From: Manuel, John <John.Manuel@lincs.police.uk>
Sent: 17 August 2023 08:55
To: _planningadvice
Subject: H09-0699-23 Caudwell Farm Holbeach St Matthews (Solar Array)
Attachments: No Objs Caudwell Fm Holbeach St Matthews (49.9MW Solar Array) jm 08.23.docx

H09-0699-23

Erection of a 49.9MW Ground Mounted Solar Array with Associated Underground Cable Route, Substation with POC Mast, Battery Storage and Ancillary Equipment & Structures

Caudwell Farm Holbeach St Matthews

Drawing file: H09-0699-23 / 4.6 CCTV Details.pdf

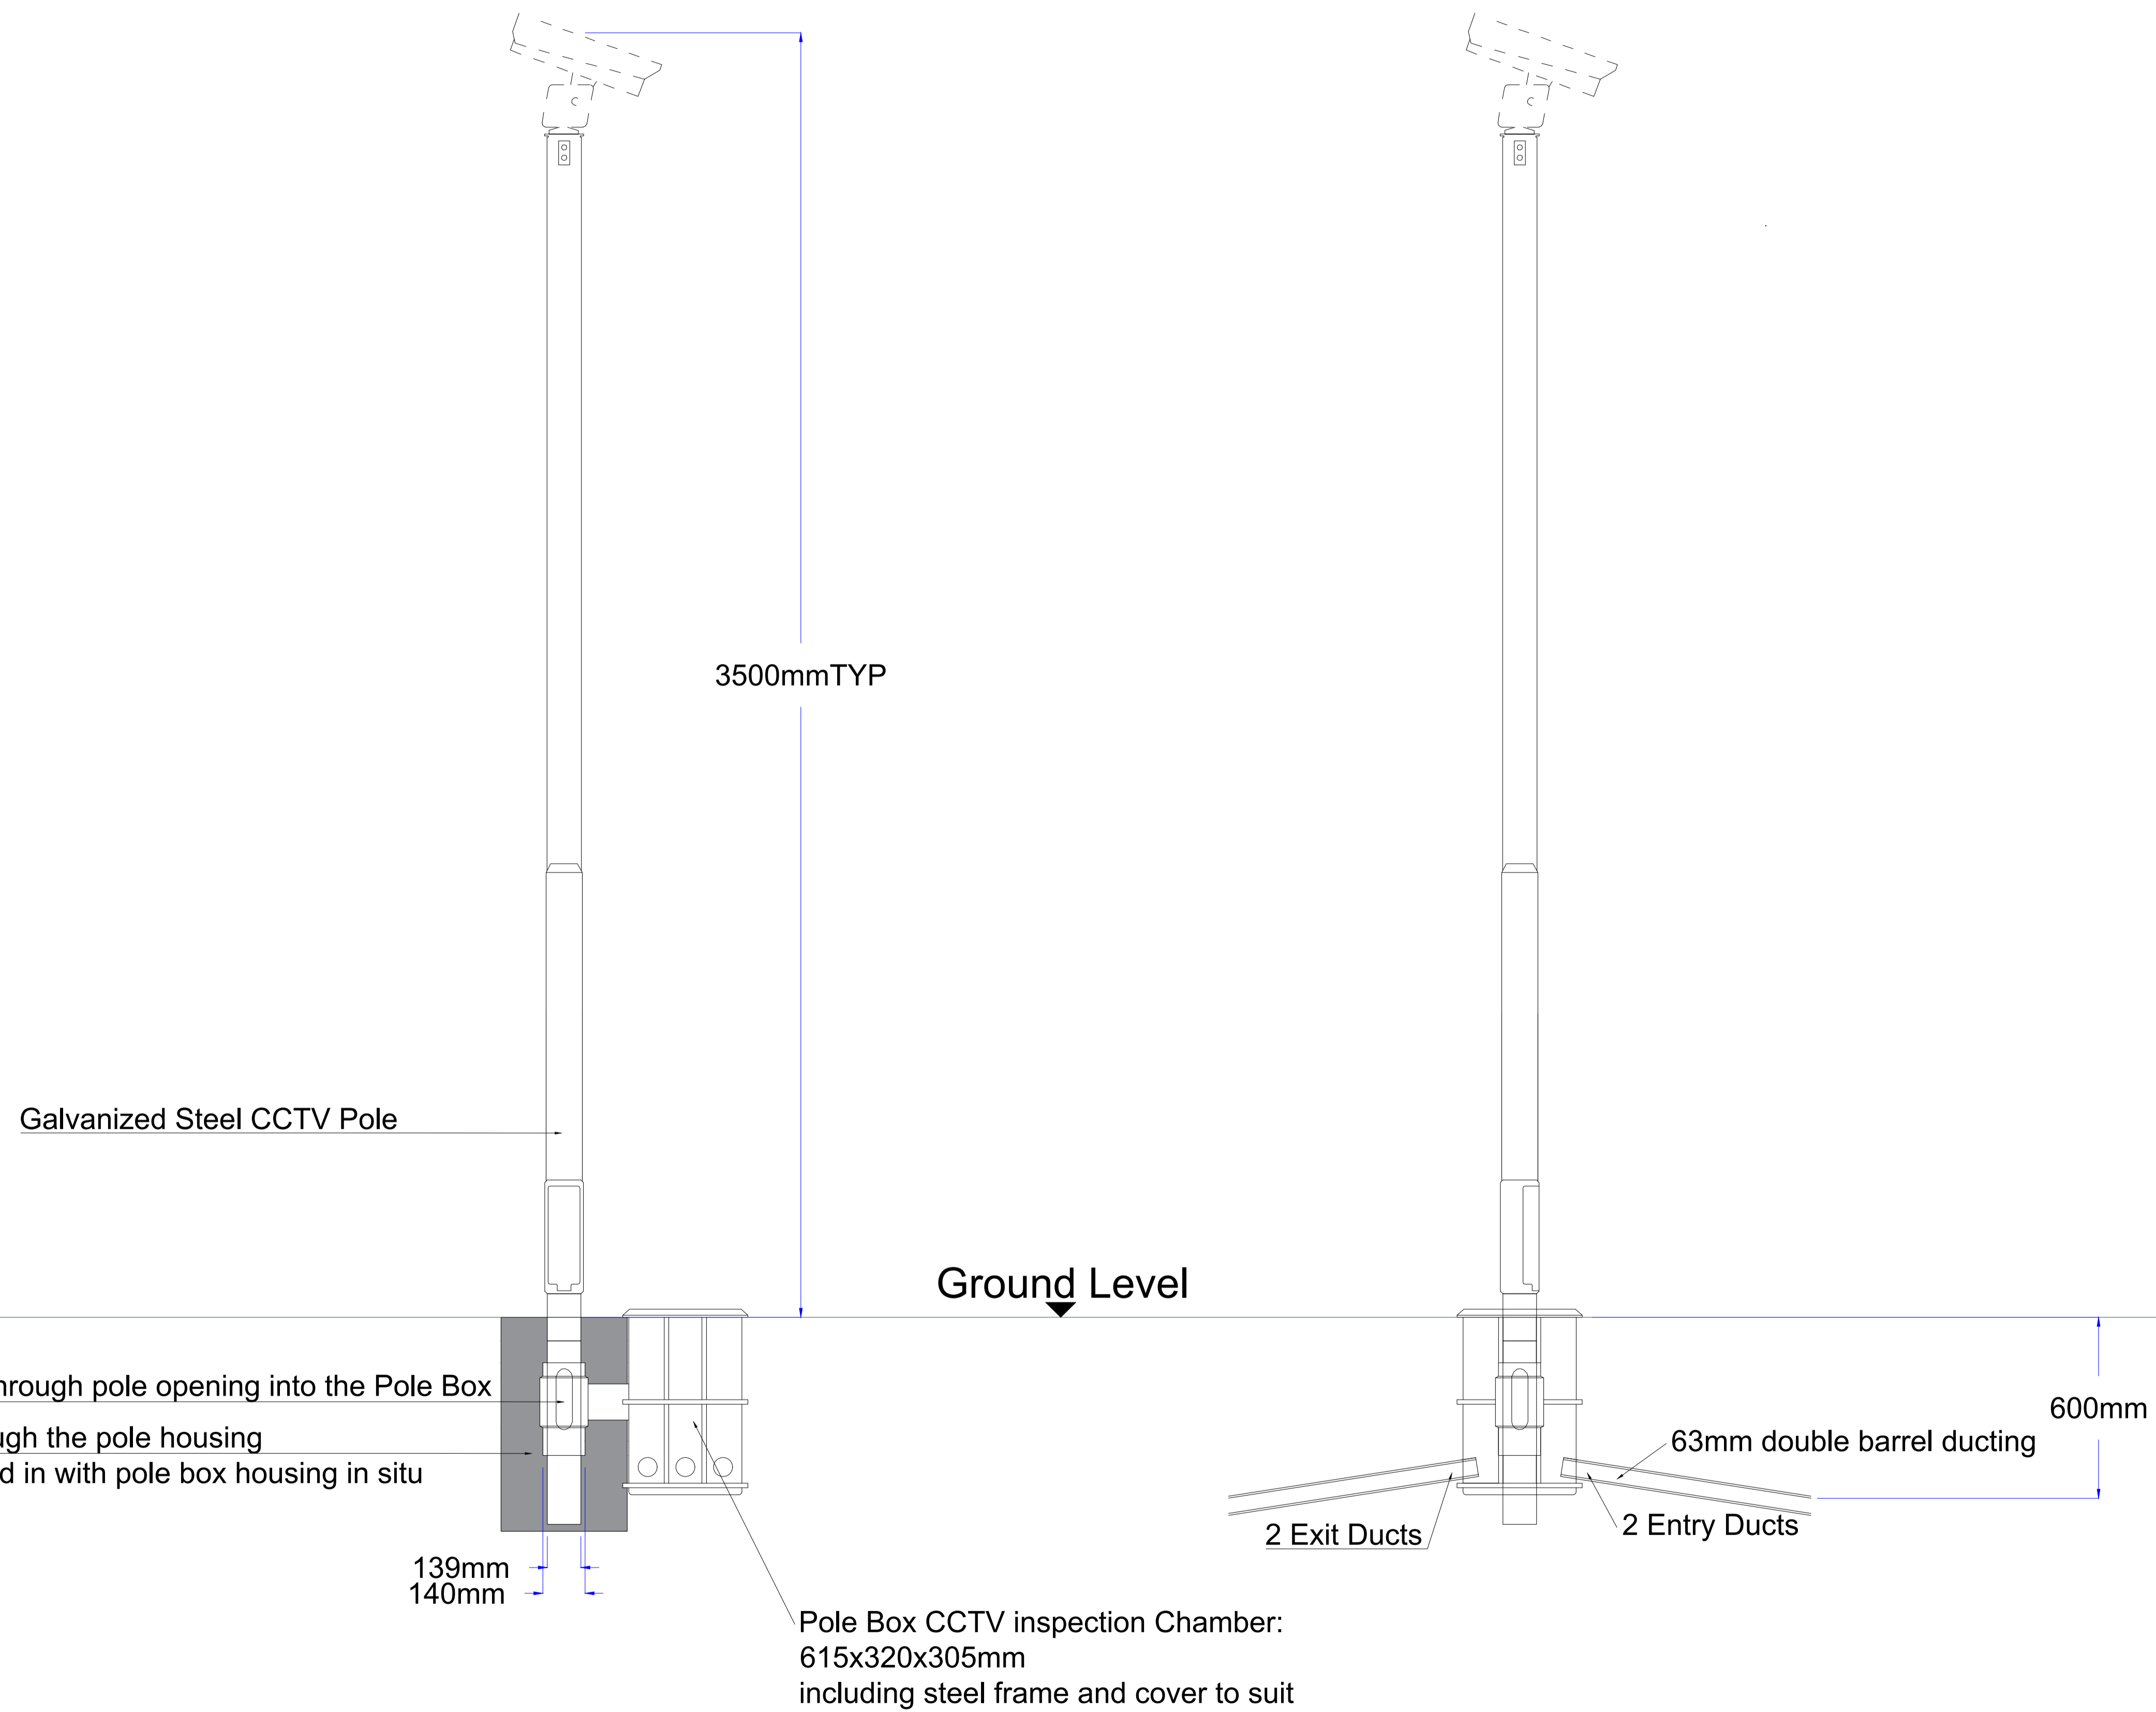
Whilst considering the often-isolated locations that Solar Farms are to be installed the installation of a remotely **monitored** with motion detection CCTV system is an effective deterrent and is most likely to provide effective evidence should a crime occur.

Installers of remotely monitored detector activated CCTV systems will comply with all of the following standards and guidelines:

- NPCC Security Systems Policy
- BS 8418 Installation and remote monitoring of detector activated CCTV systems – Code of Practice
- BS EN 50132-7: CCTV Application guidelines

There will probably be little reward in deploying CCTV or other defence unless it is monitored in some way or can provide an instant alert in some form.

Drawing file: H09-0699-23 / 4.7 Securtiy Fence and Gateways.pdf

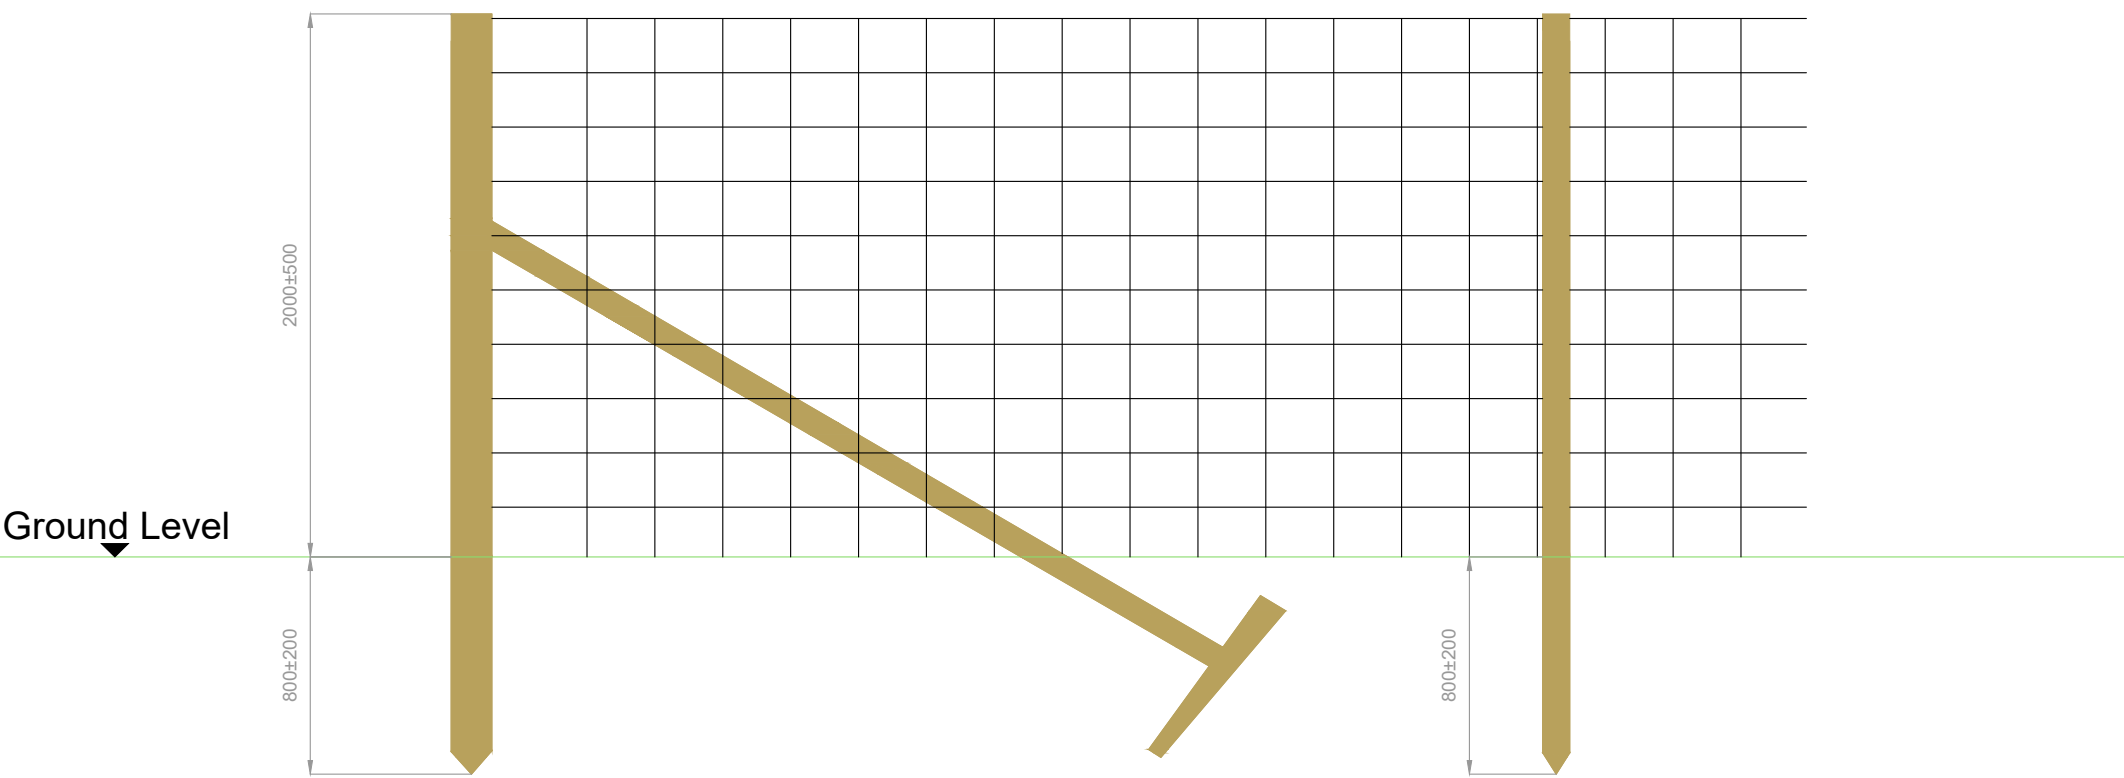
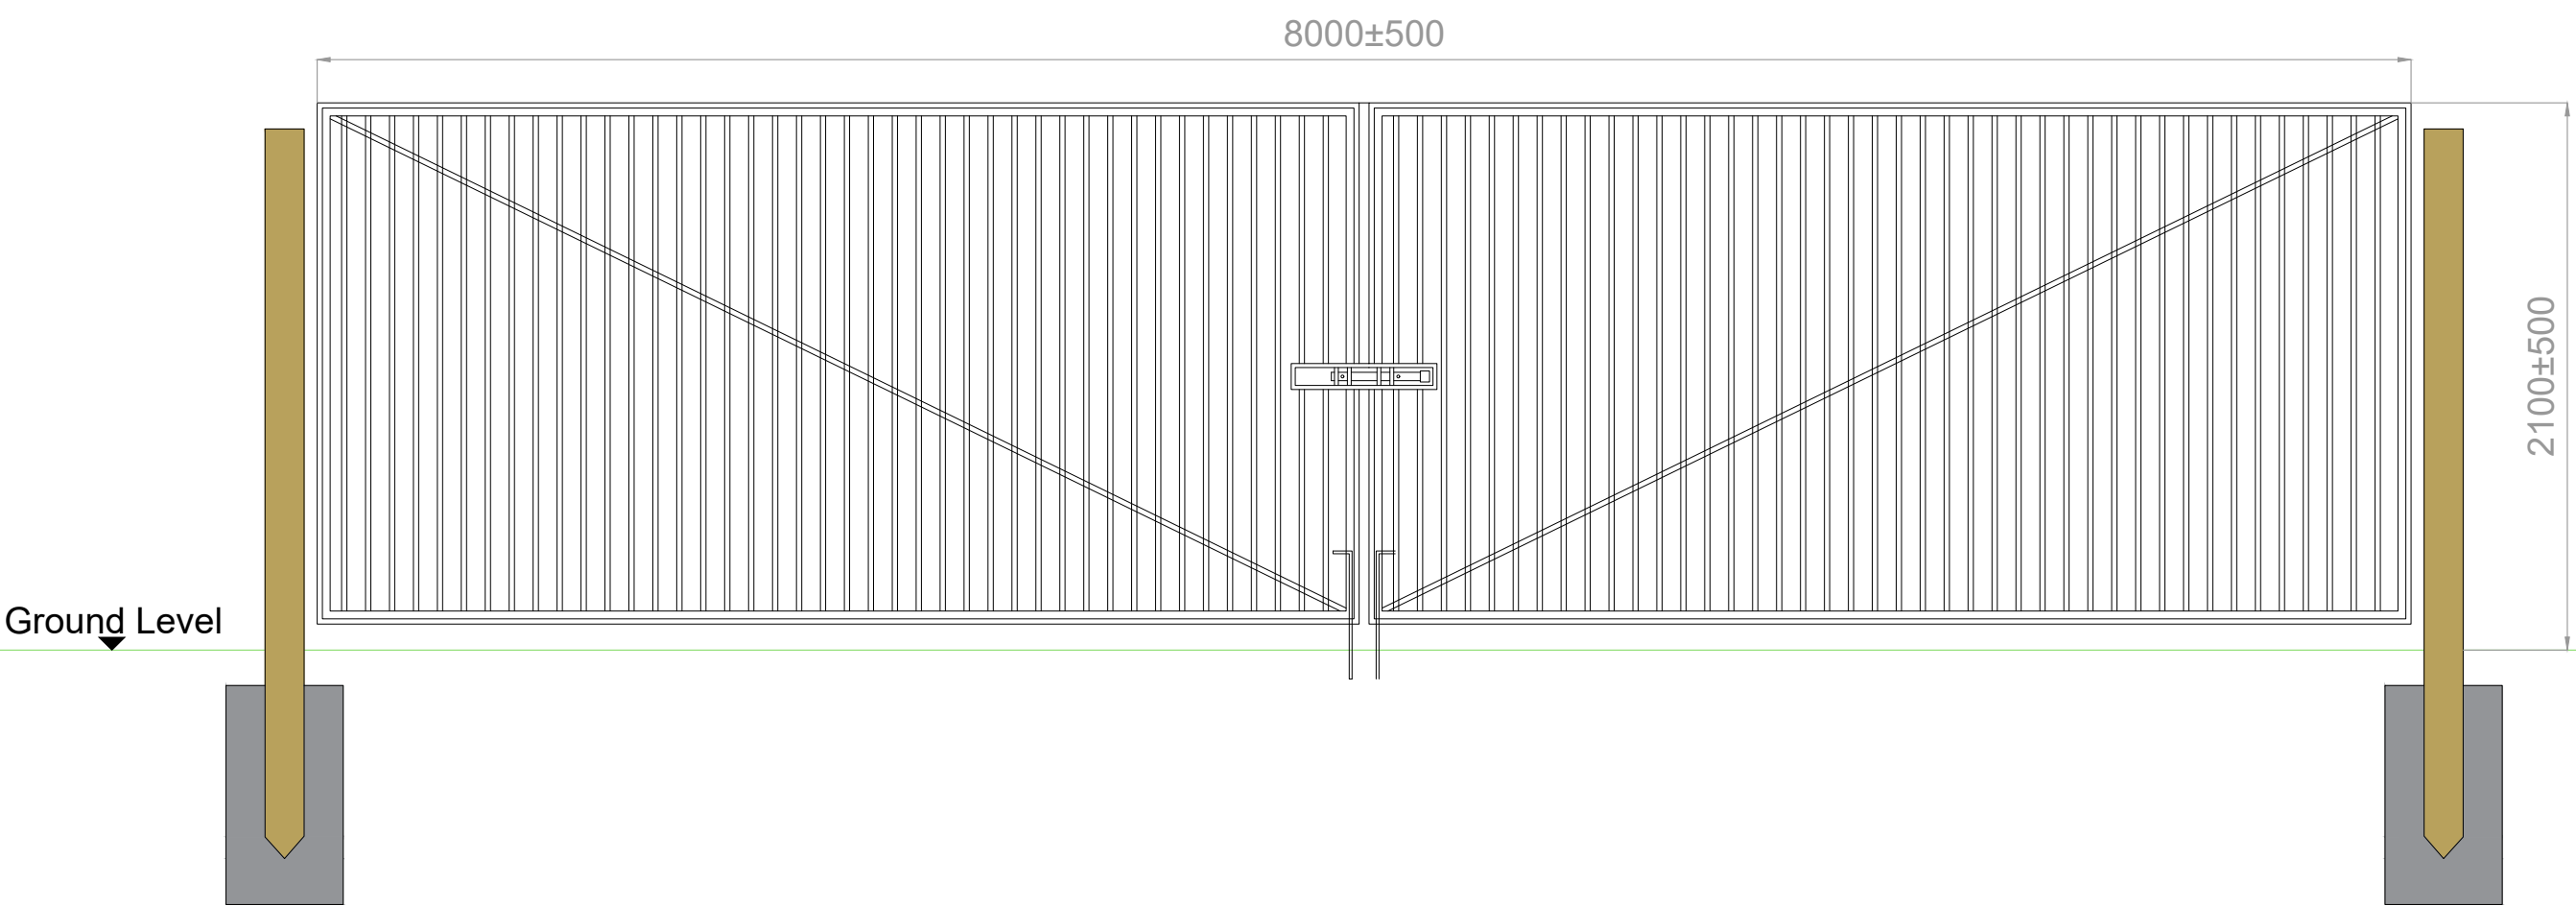
I would recommend that the boundary fence is to a minimum of LPS 1175 level 3 and to a height of 2.4 metres or to the current UK Government standard, SEAP (Security Equipment Approval Panel) class 1-3.

The use of 2.4 metre welded mesh fencing (in green) would be the most unobtrusive method of providing a secure perimeter border. All gated entrances should be secured with commensurate and gated access systems.
